**Subject:** Planning Consultation on: BN/17/21/PL

**Application ref:** BN/17/21/PL

**Description:** 1 No; new dwelling. This application is a Departure from the Development Plan & is in CIL Zone 3 & is CIL Liable as new dwelling.

**Location:** The Cottage Highground Lane Barnham PO22 0BT

DRAWING TITLE:
PROPOSED DWELLING ADJACENT TO
EXISTING DWELLING
Proposed Landscaping &
Biodiversity Plan

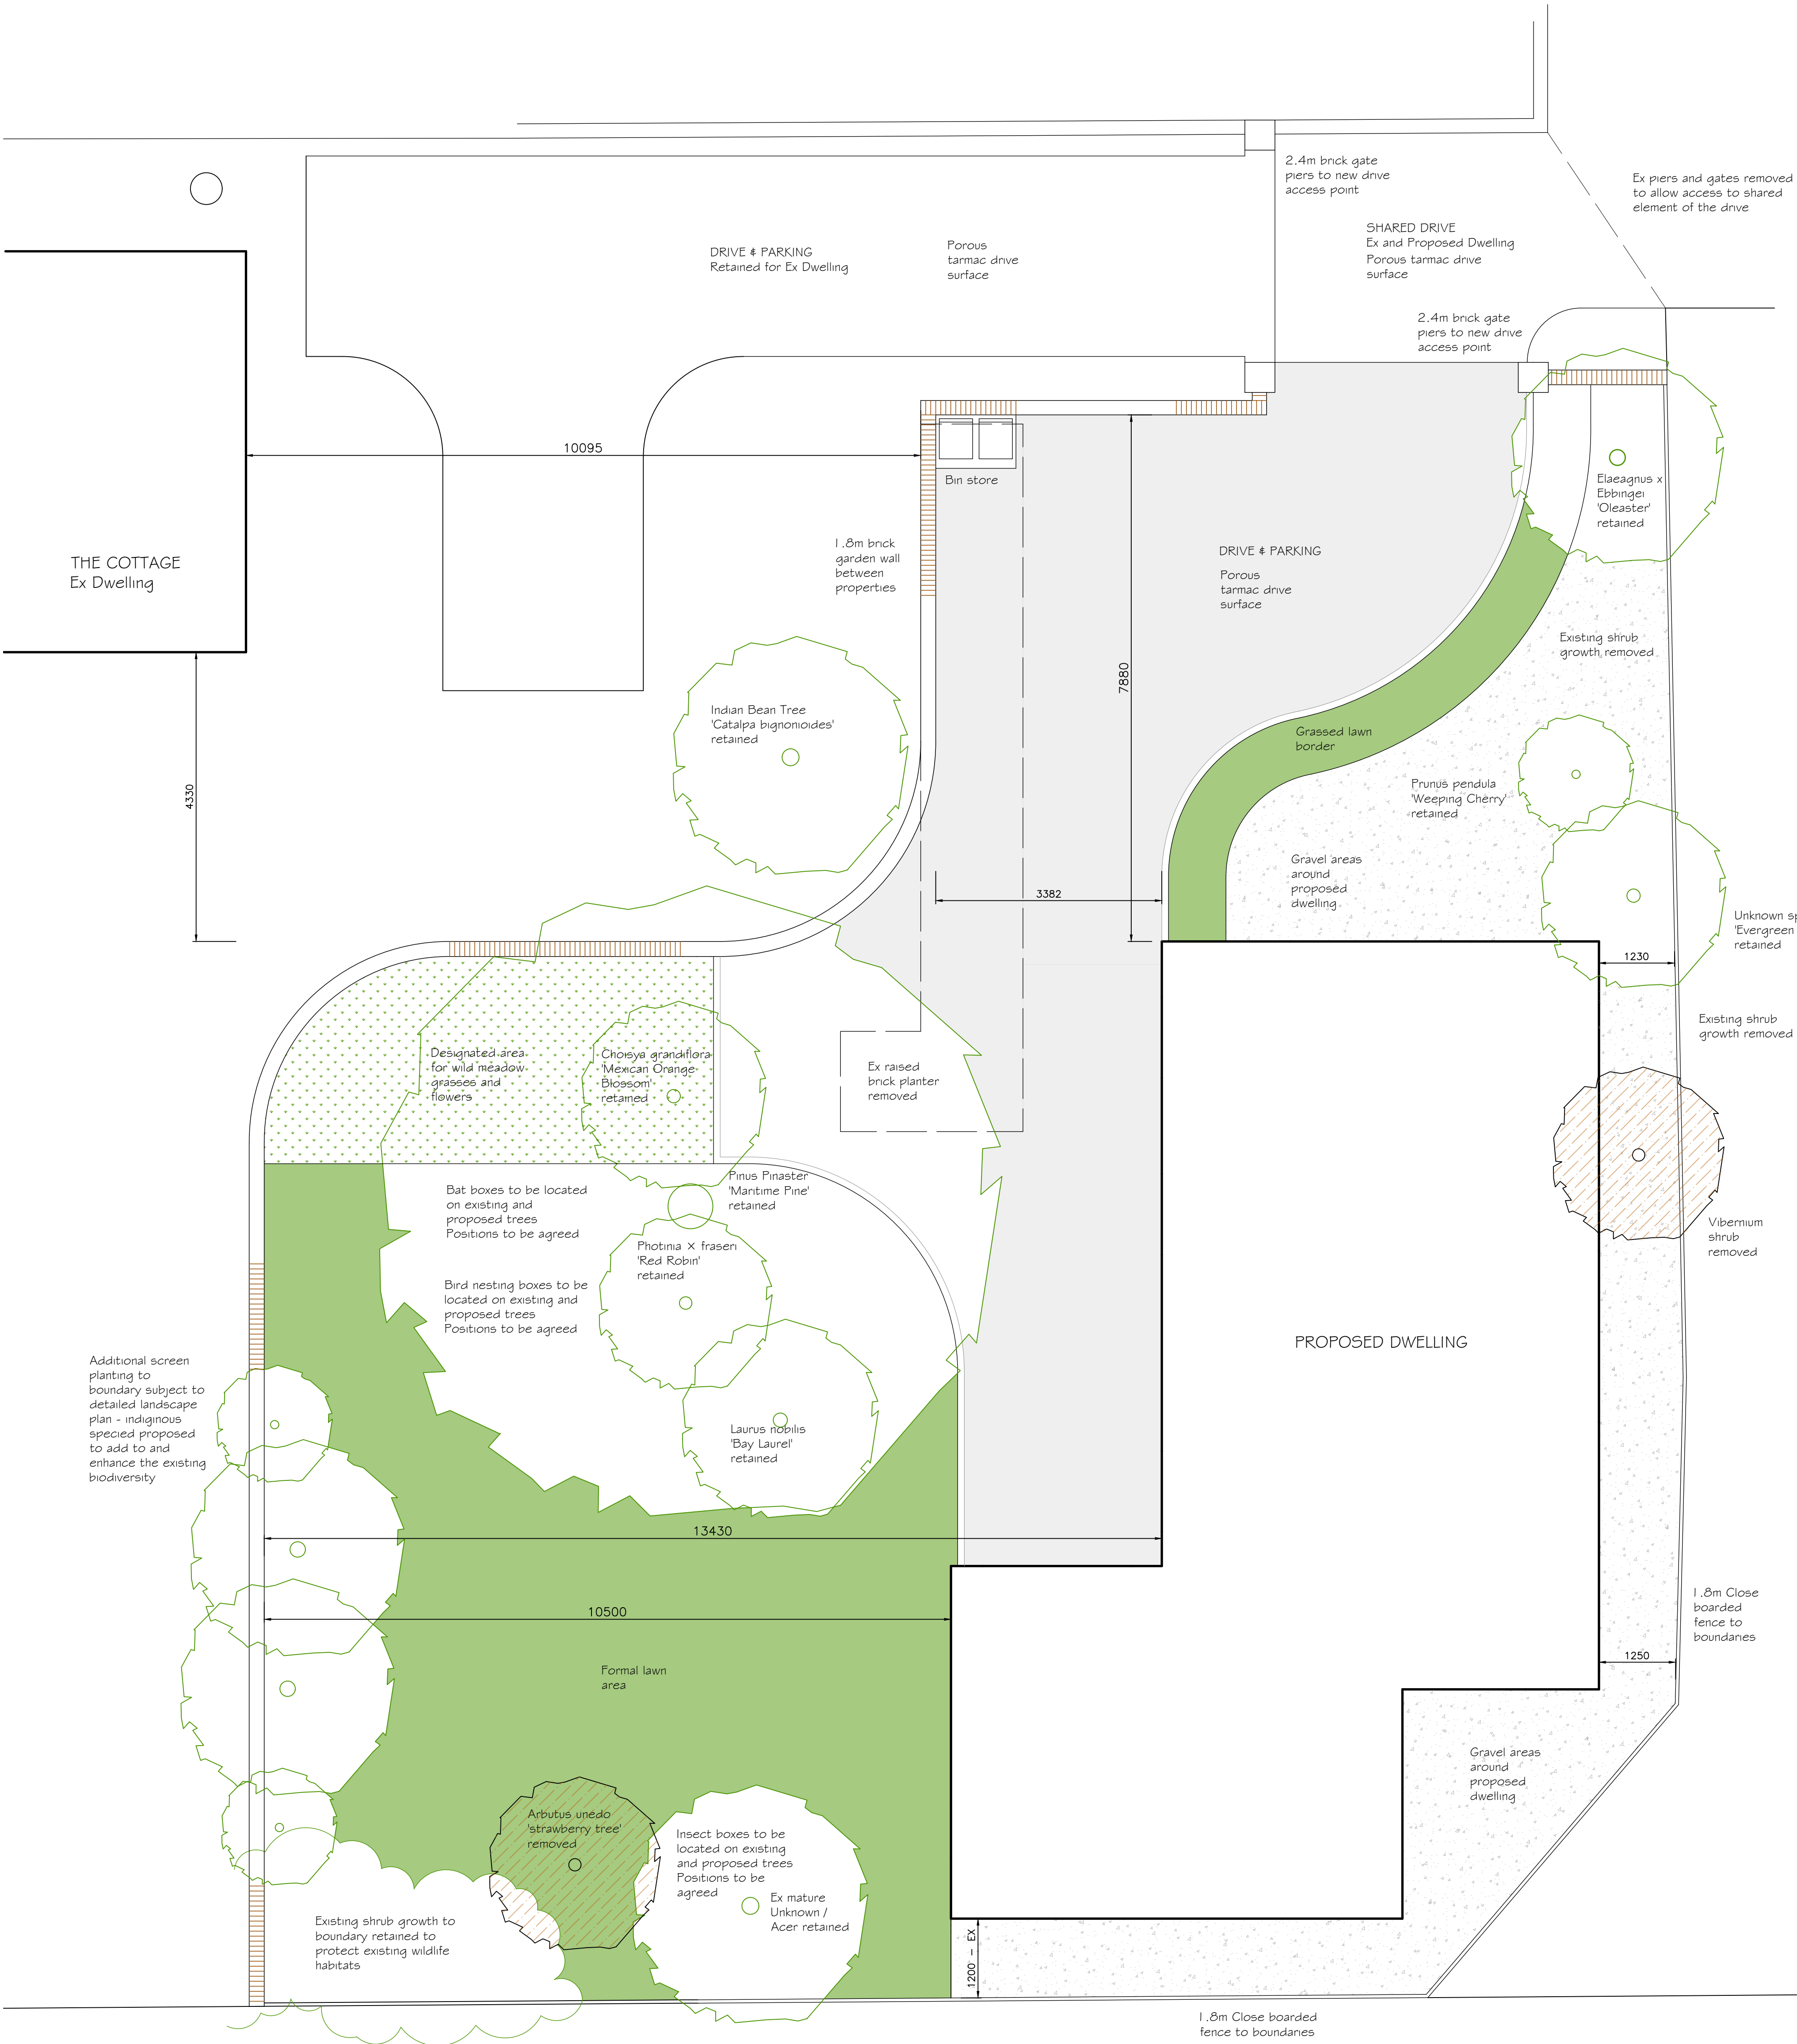
The NPPF para 124/127 relate to good design principles which equally apply to small infill and replacement development. The indicative site layouts and tree protection plans has made reference to indicative planting alongside tree retention. These details would require expanding in the form of a detailed planting plan and specification detailing species choice, actual plant quantities, planting densities and size at time of planting. Detail should also be provided regarding existing trees and boundary planting.

Landscape provision to the dwelling and improvement with native species infill plus further boundary screening as required. All proposed planting should be considered and its connection for biodiversity and habitat explored, with a biodiversity net gain following development. Trees specified should be at a size which allow instant impact, but which will establish and mature as the site develops.

I would recommend no landscape objection in general to the proposals subject to submission of landscape details to provide ornamental and native improvements and potential biodiversity gain. To confirm tree protection methods in relation within and beyond the site boundary that may be affected by the development proposals.
